18 May 2021
Our Ref: 21446A.BMcD_Council

**Re: Objection to State Significant Development Proposal (SSD – 10464)
Proposed New Hotel/Residential Building Stage 1 Development
Application
50 – 52 Phillip Street, Sydney**

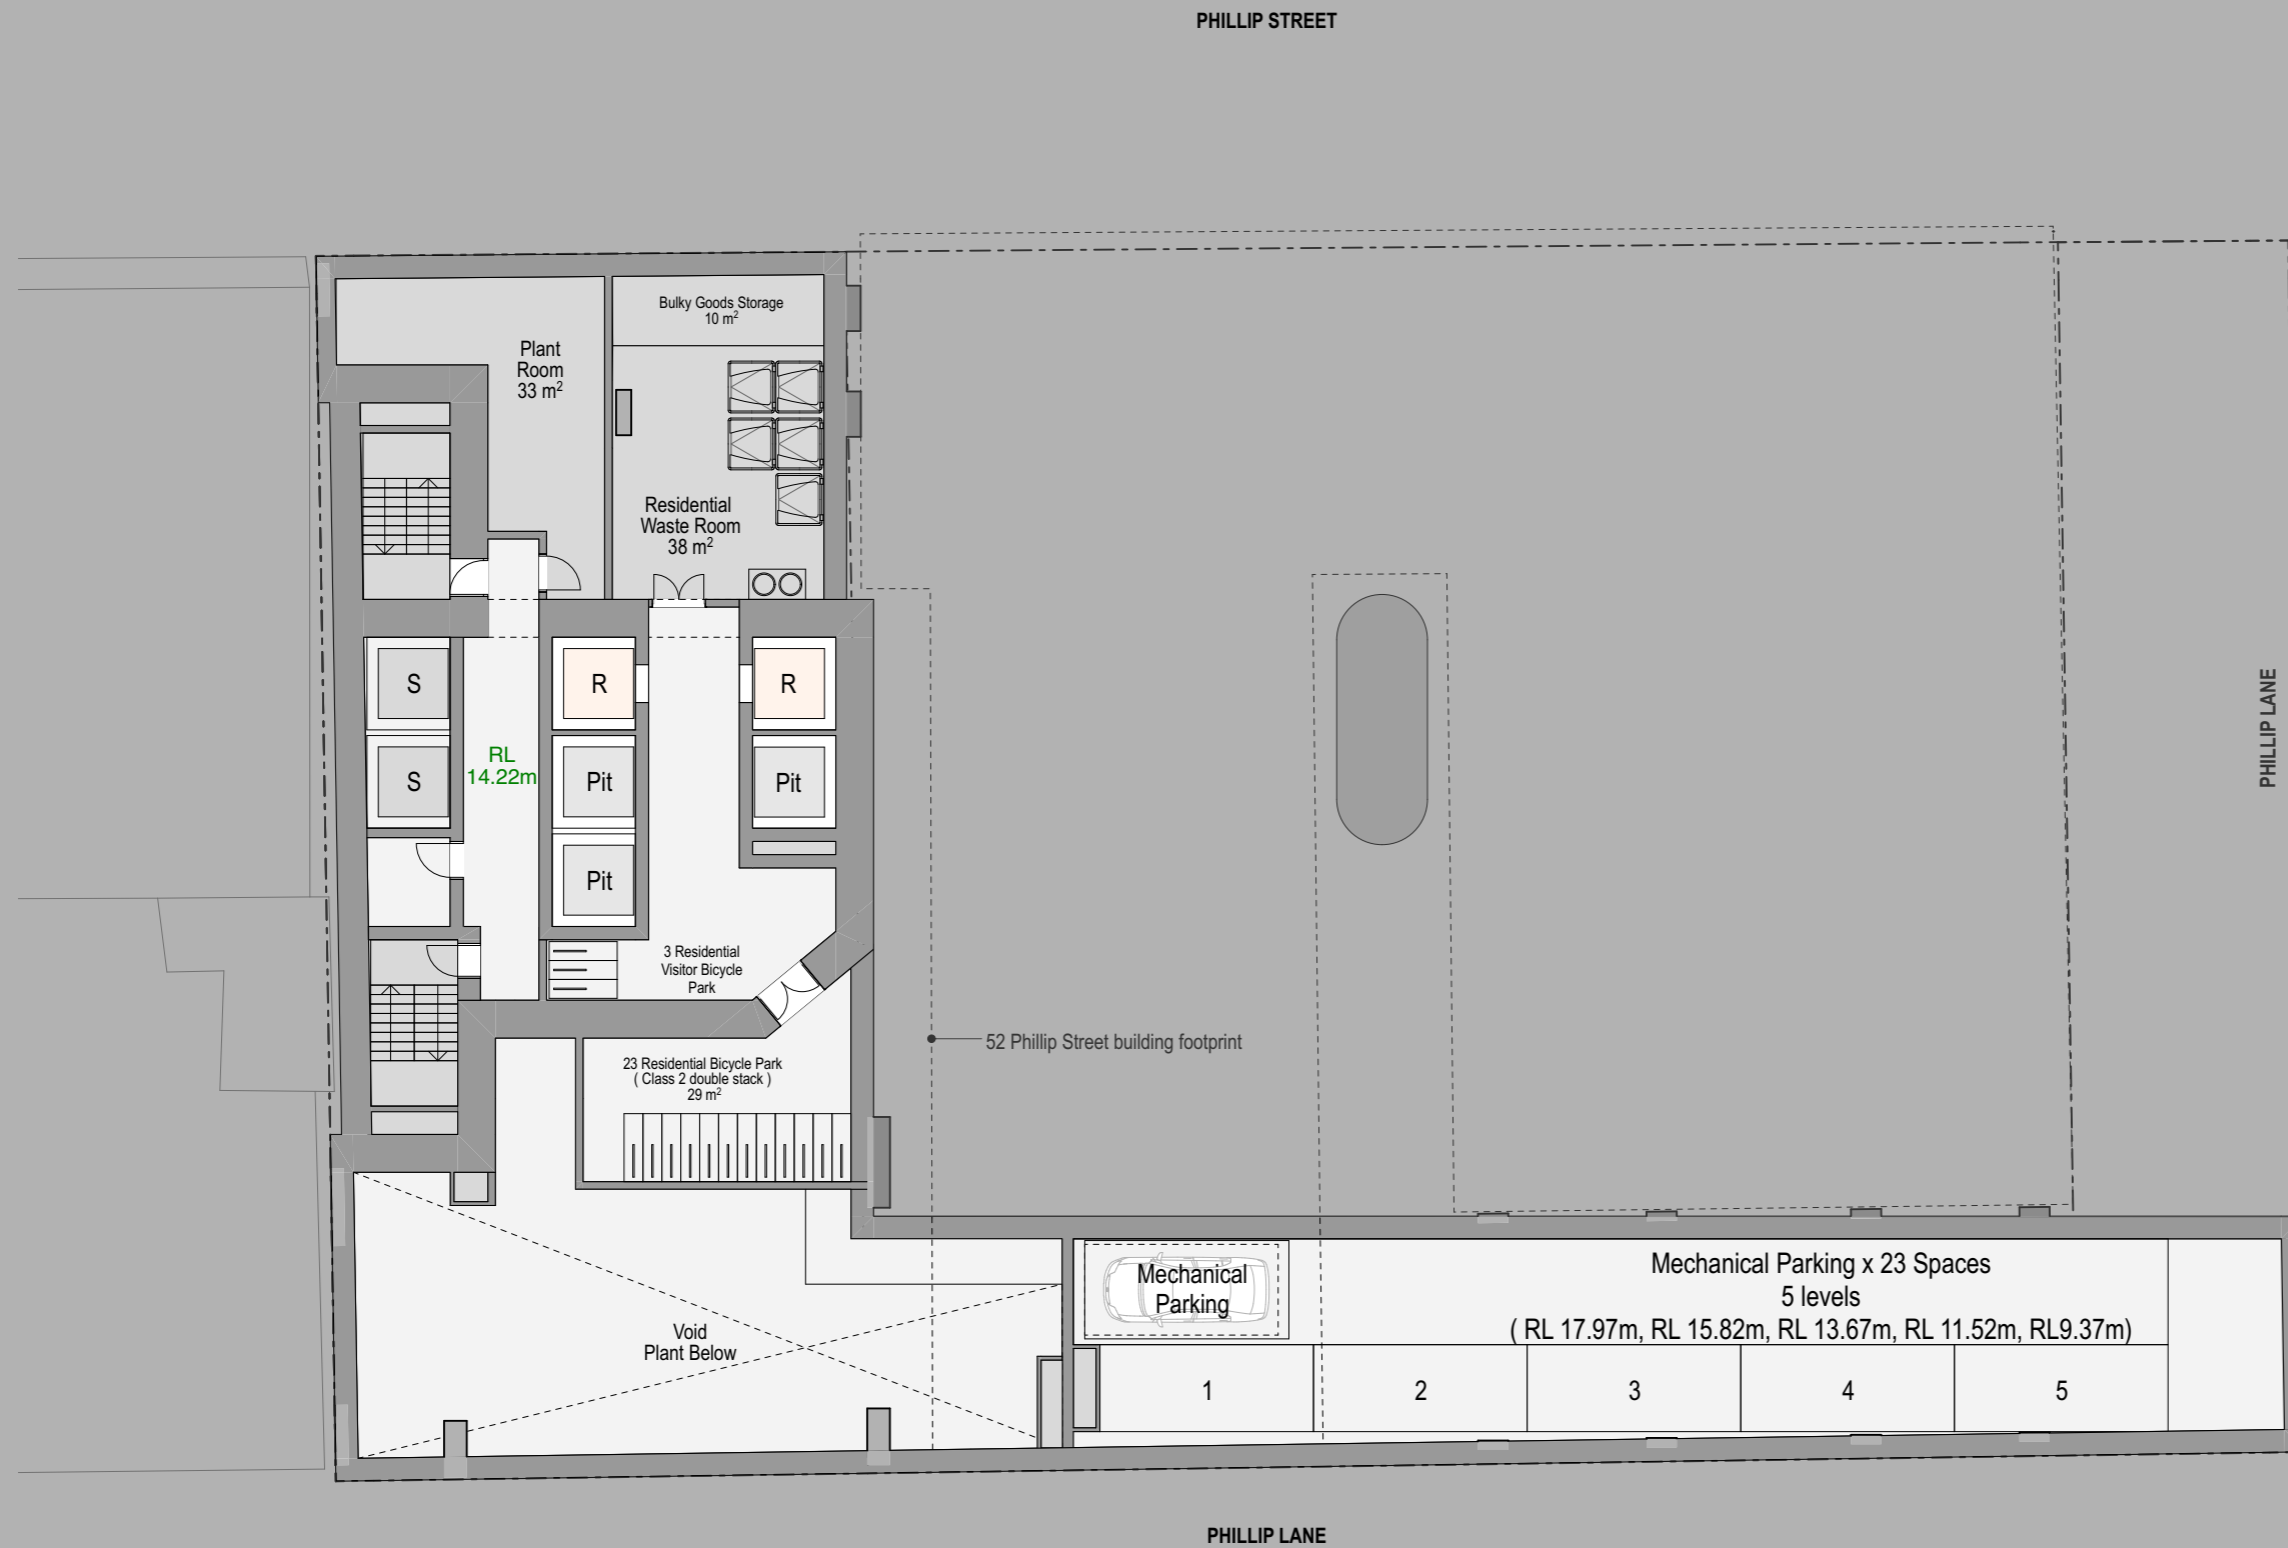
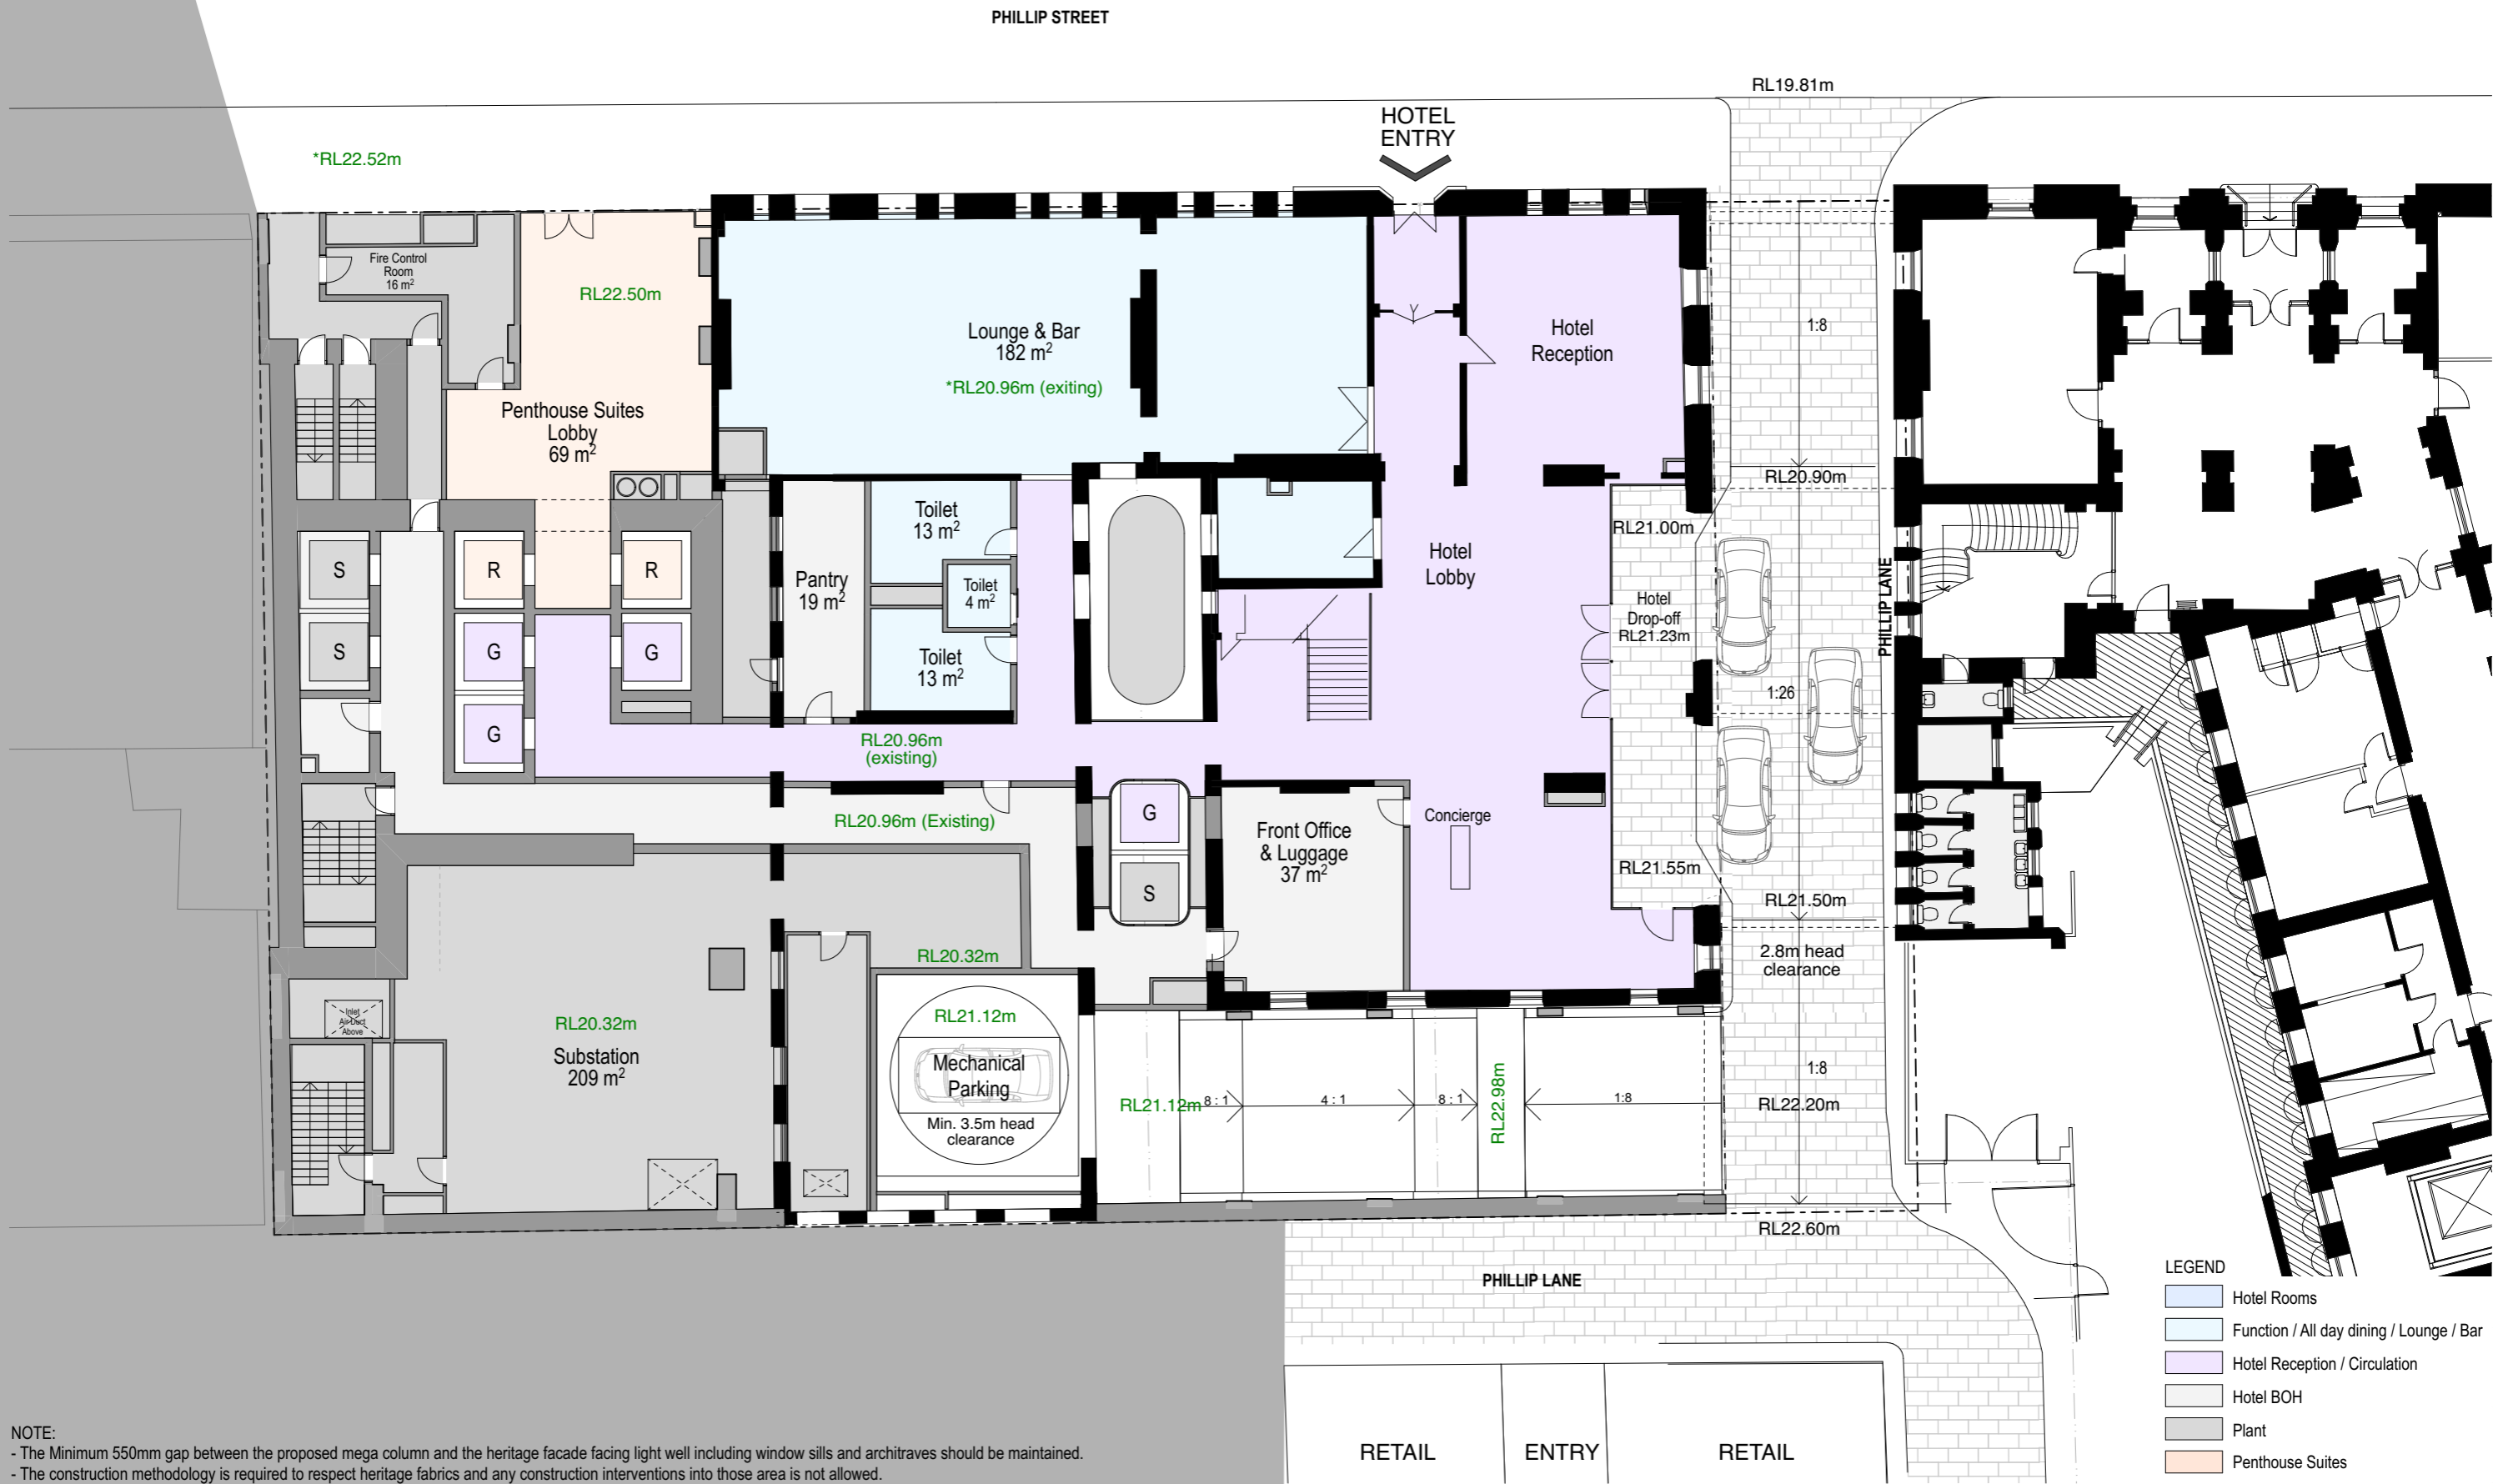
The lightwell space is about 3.5 metres wide. The sketches in the report indicate that the permanent footing will occupy the entire ground level of the lightwell. The concept plans show approximately 500mm clearance between the column and the walls of the lightwell. It is not difficult to draw this form of construction. Building it is another matter. It is conceivable that the restricted space will necessitate greater intervention into the wall and window fabric to enable construction processes. A clue to the eventual outcome is that, where the lifts have previously been inserted, there are walls flanking the lift shaft that are not original as shown in the fabric analysis in the Conservation Management Plan.

Furthermore, windows will look at the large column 500mm away. There is no room for people to access the space for construction or maintenance afterwards. There would be non-structural consequences; not the least that the lightwell would no longer serve its originally intended purpose. It does have heritage significance for its function; the extant walls and windows are rated as high significance. It is not simply a hole in the building to facilitate construction of a very large column.
